Your ref: SSD 8895

19 September 2018

**STATE SIGNIFICANT DEVELOPMENT 8895 – WELLINGTON NORTH SOLAR PLANT**

**PROPERTY:** Lots 75-84, 88, 119-121, DP 2987, Lots 1 & 2 DP 1104720, Lot 3 DP 976701, Lots 1-3 DP 808748, Lot 100 DP 750760, Lot 1 DP 664645 and Lot 1 DP 1206579, No. 6444 Goolma Road, Bodangora

Figure 13: 1:2000 Visual Impact Mitigation Principles

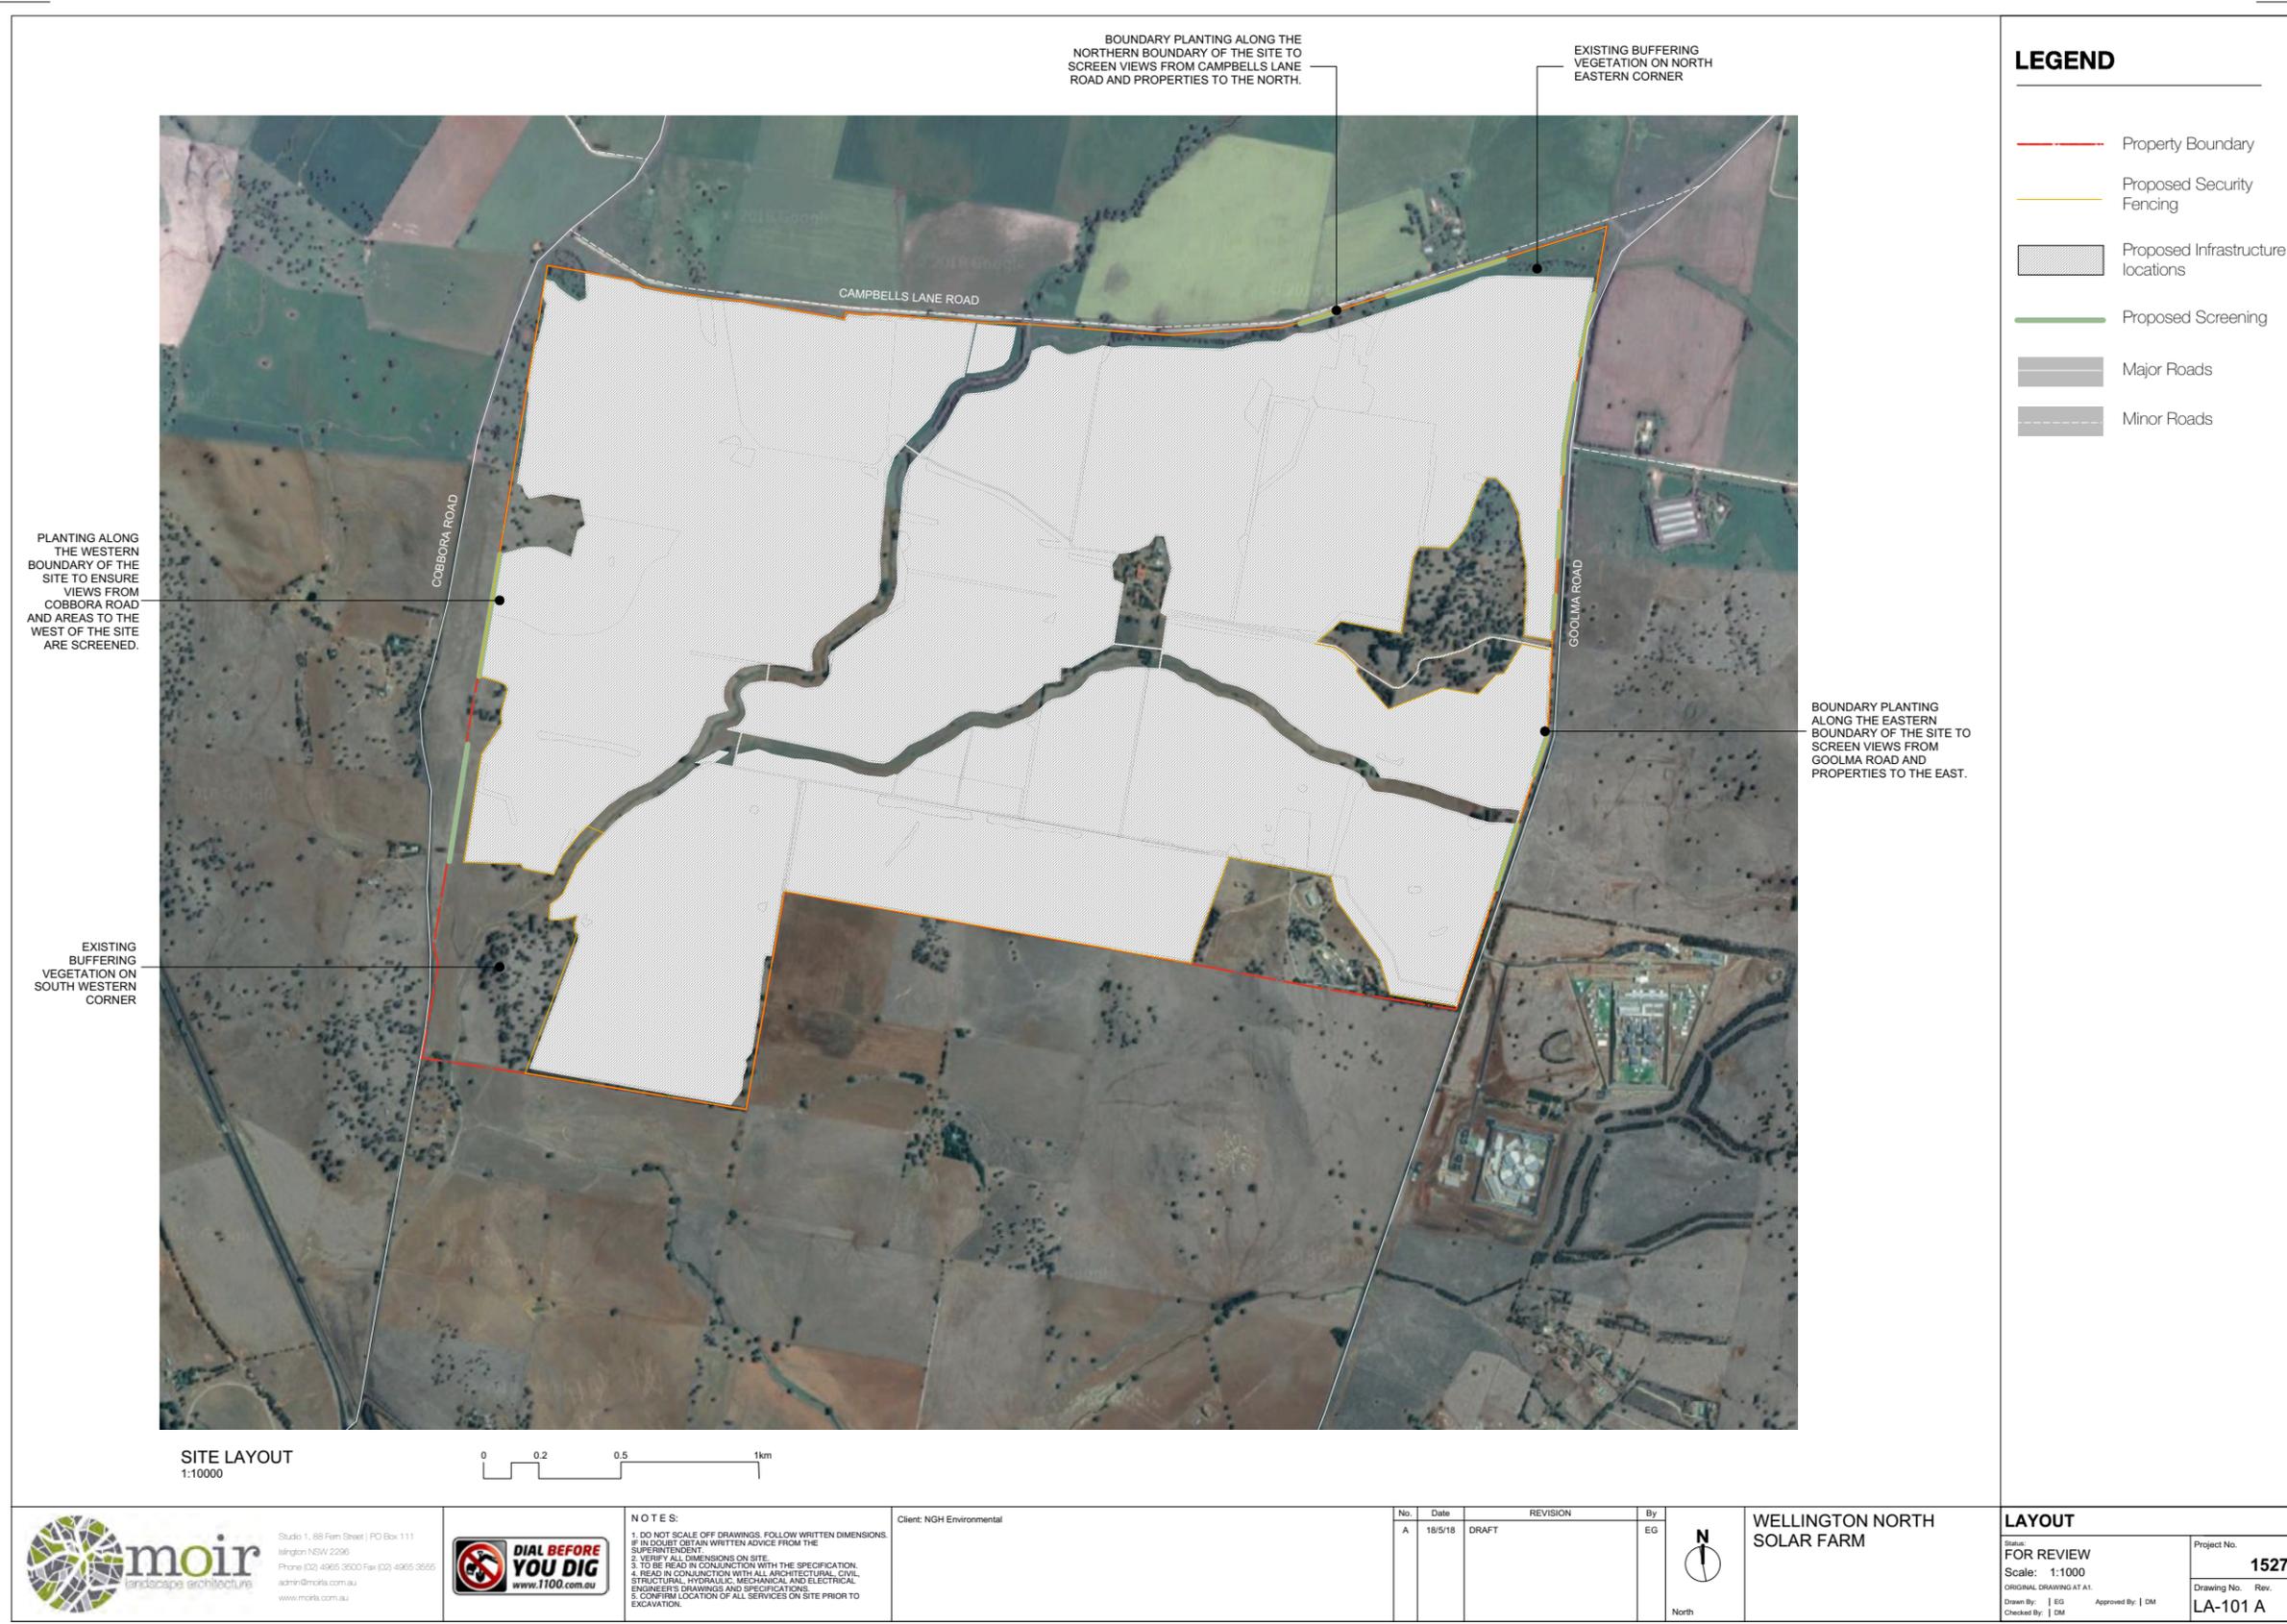
Council notes plans which indicate the inclusion of landscaping at certain points around the perimeter of the development. In order to offset any visual concerns, the implementation of a landscape buffer around the entire perimeter of the development is requested where there is no existing visual buffer through existing landscaping or topographical features. In this regard, Dubbo Regional Council requests a condition be included on the consent that prior to issue of a Construction Certificate a detailed Landscape Plan be submitted for approval which includes details of:

It is further requested the landscaping have a minimum mature height of 3 metres utilising deep rooted, water tolerant, native plant species endemic to the Wellington local area. Dubbo Regional Council staff can be consulted on the type of species chosen. Such landscaping as a minimum should be undertaken in stages to correlate with the construction of the adjacent solar panel(s).

## APPENDIX 5: ROAD UPGRADES AND SITE ACCESS

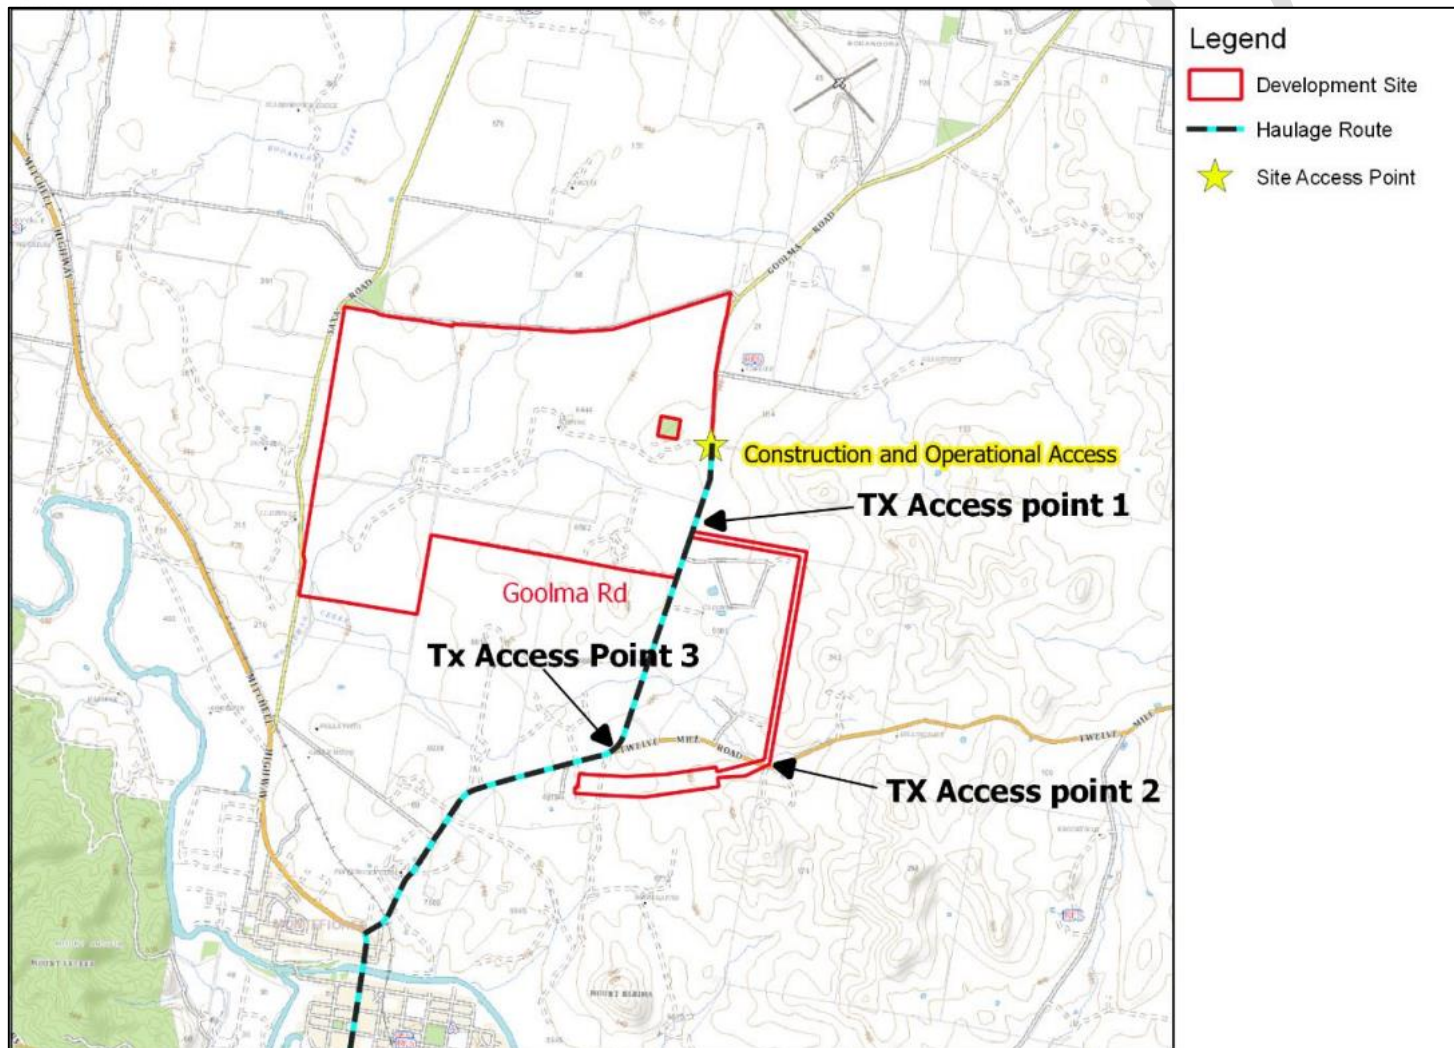
Based on the information submitted, it appears the primary access to the development will be via Campbells Lane, with two (2) secondary access points located on Goolma Road. In addition to those works identified in the EIS, and any comments raised by NSW Roads and Maritime Services, Dubbo Regional Council requests the following road upgrades be undertaken:

- Campbells Road from Cobbora Road to Site Access 1 shall be bitumen sealed to Dubbo Regional Council's rural road standard being a minimum of 7.5 metre wide bitumen sealed two-way carriageway;

- Intersection of Cobbora Road and Campbells Lane – Upgrade of the intersection to allow B-double vehicles to safely turn;
- Site Access 1 –Upgrades to this entry point shall be carried out in line with Council standards (STD1264) for B-double vehicles. The BAR and BAL upgrades as proposed in the Environmental Impact Statement would be required to allow sufficient space for the turning of B-Double vehicles;

- Site Access 2 and 3 – Upgrades to accommodate B-double vehicles in accordance with Council standards (STD1264);
- Goolma Road currently has high traffic volumes generated from the two (2) Wellington Correctional Centres. The impact of additional traffic volumes generated from the construction works shall be considered in the design of Site Accesses 2 and 3;

- Advisory signs shall be located adjacent to the Cobbora Road/Campbells Lane intersection, and Site Accesses 1, 2 and 3, indicating high volumes of turning heavy vehicles; and

- All gates be setback a minimum of 26 metres from the property boundary to permit a B-Double vehicle to fully stand within the property boundary and not overhang onto the road reserve while any access gates are being opened or closed.

The intersection and site access upgrades stipulated shall be undertaken to allow B-Double vehicles to safely negotiate each intersection/access without being required to cross on to the incorrect side of the road at any time to negotiate the turning movement. Detailed plans submitted for such construction works should demonstrate this detail.

APPENDIX 1: GENERAL LAYOUT OF DEVELOPMENT

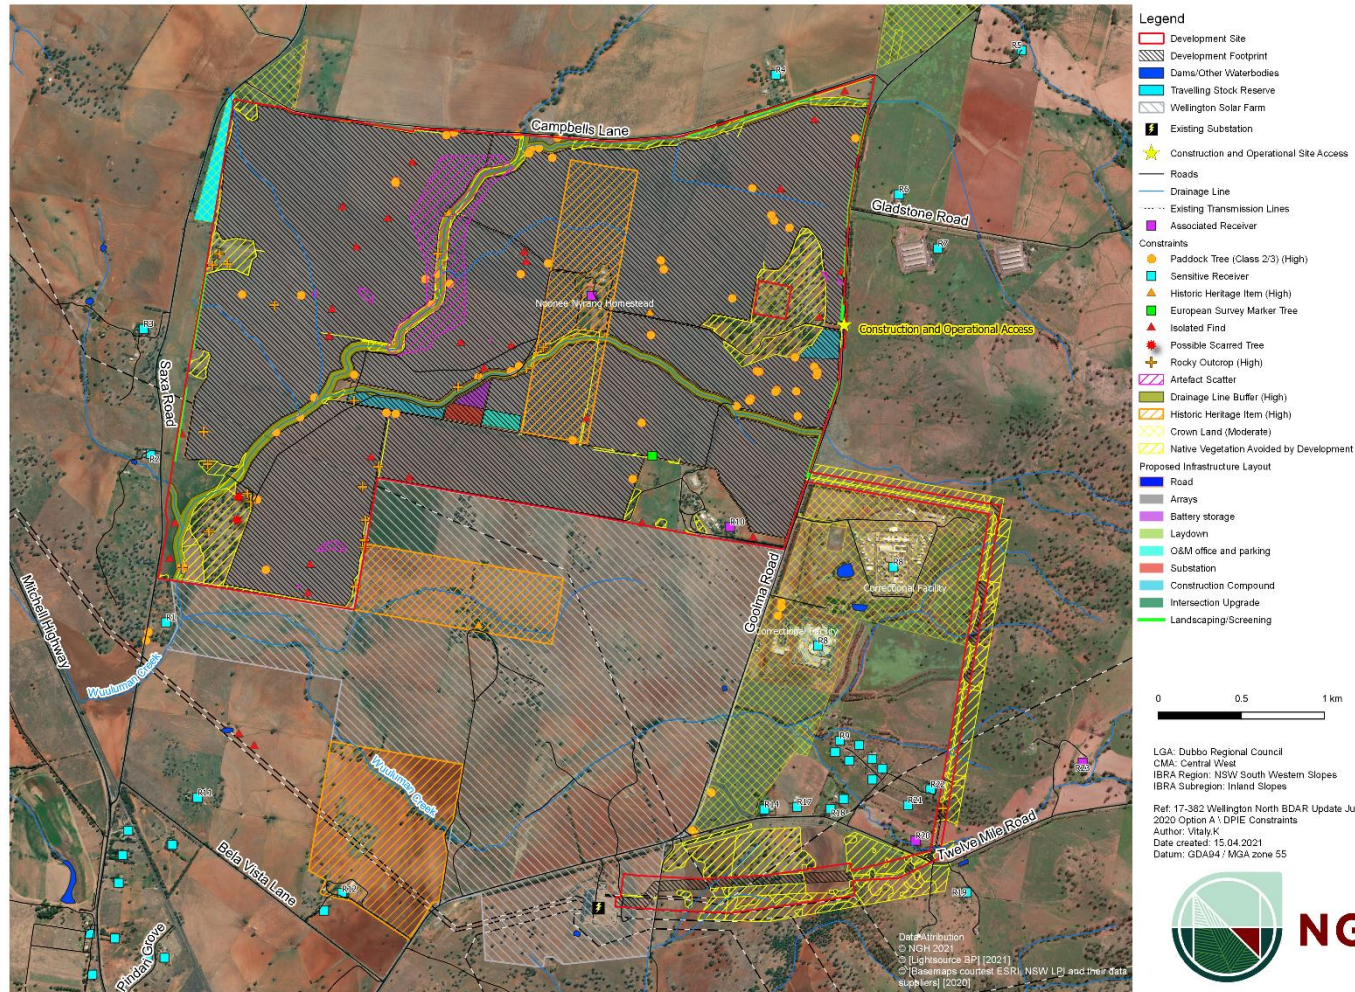
Reference is made to the proposal plans shown in Appendix 2 of the EIS. In some areas it appears the photovoltaic arrays will extend to the property boundaries, however without a detailed plan this is difficult to determine. It is therefore suggested the arrays be suitably setback from property boundaries to ensure suitable vehicular access can occur to the perimeter fencing, landscaping and arrays for the maintenance and servicing of such.

It is noted the subject site comprises various water courses (mostly ephemeral). Review of the submitted plans demonstrates the Photovoltaic Arrays are located across some of these water courses. Further, internal roadways and transmission lines also appear to cross the waterways. Based on the plans submitted, it is difficult to determine the proximity of the development to any waterways and whether recommended clearances are achieved.
